Subject: FW: Further Information Required on Your Ref: PP-08621240 Our Ref:BE/35/20/HH

I agree to the amended description, and attach amended location plan and block plan together with CIL additional information form.

PROPOSED FIRST FLOOR PLAN

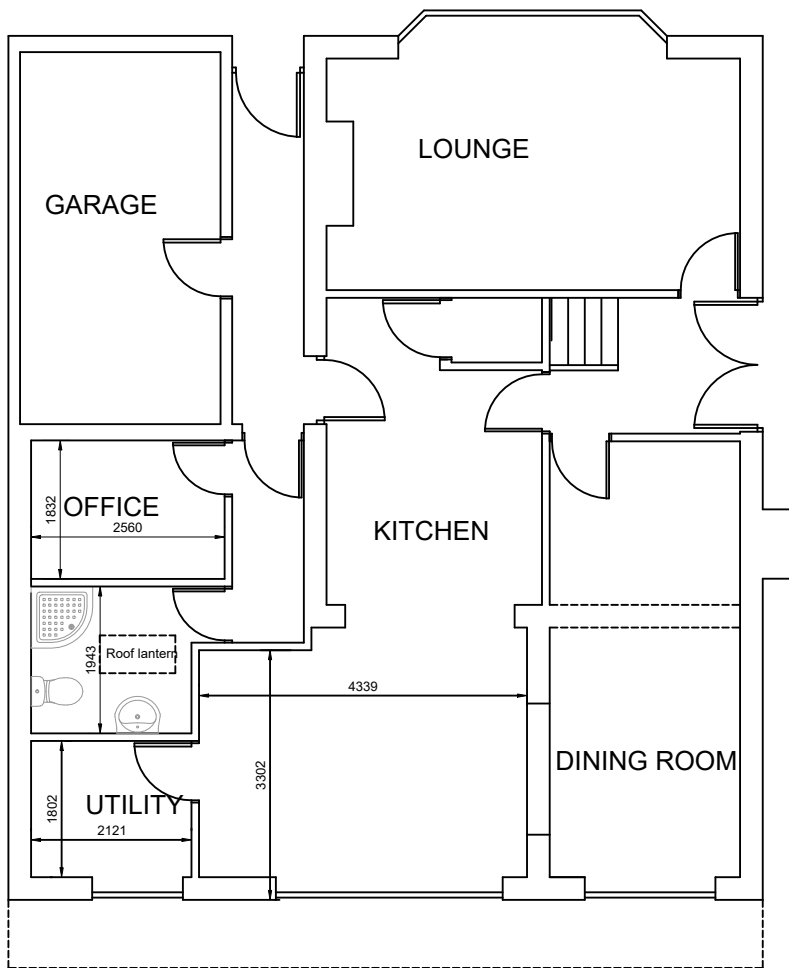
However, I am unable to find any inconsistency between the first floor plan and elevations-the first floor extension is shown stepped in 300mm on both, so I must ask for clarification on this item.
